DEADLINE 9 RESPONSE

KENT DOWNS AONB UNIT RESPONSE TO APPLICANT'S SUBMISSIONS AT DEADLINE 8

**Response to Applicants Post Hearing Submission to ISH 11
[\[REP8-110\]](#), incorporating:**

*Local Landscape Character Area boundaries of the Kent Downs AONB LCA, West Kent Downs, Sub-areas Cobham and Shorne*

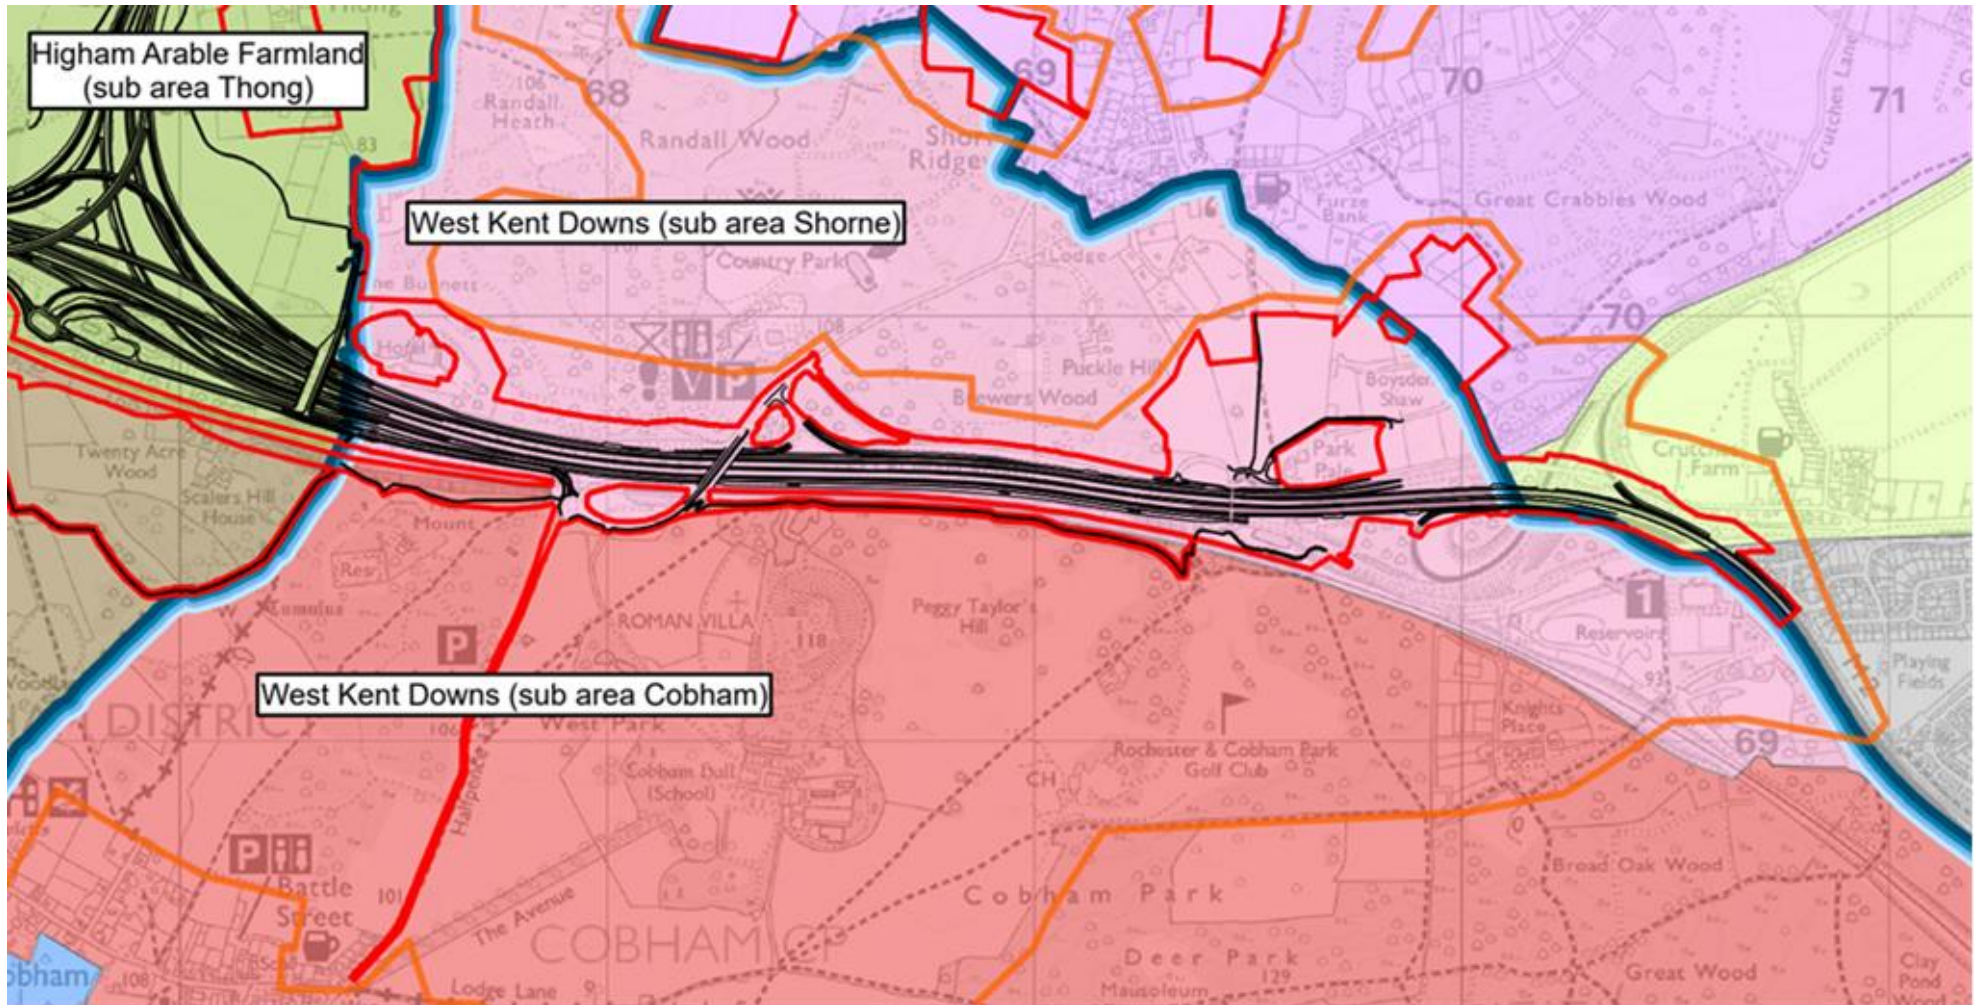
At A5.8 it is advised that *'The Applicant also notes that using the published landscape character area boundary in the Kent Downs AONB Landscape Character Assessment Update 2020, which follows the central reservation of the A2, introduces an element of double counting to the assessment in that the loss of the existing tree belt in the central reservation is assessed in both the Cobham and Shorne LLCA sub areas'*. This is incorrect. The boundaries from the published LCA are shown in Figure 1 below, which was provided in the AONB Unit's original Written Representation [[REP1-378](#)]. The boundary between the two Sub-areas is located along the southern boundary of the east bound carriageway of the A2; the central woodland belt between the east and west bound carriageways lies wholly within the Cobham Sub-area.

At A.5.8 the Applicant advises they consider the original 2022 Assessment using their adjusted boundaries should continue to stand, rather than the revised assessment produced here. We disagree. While the 2022 Assessment predicts the same effects for the overarching West Kent Downs LCA, using the adjusted boundaries results in an under-assessment of the effects of the Cobham Sub-Area and we do not consider there to be any valid justification for this. The Kent Downs LCA was reviewed and updated in 2020 when it was not considered that a boundary adjustment for the sub-areas of Cobham/Shorne was necessary.
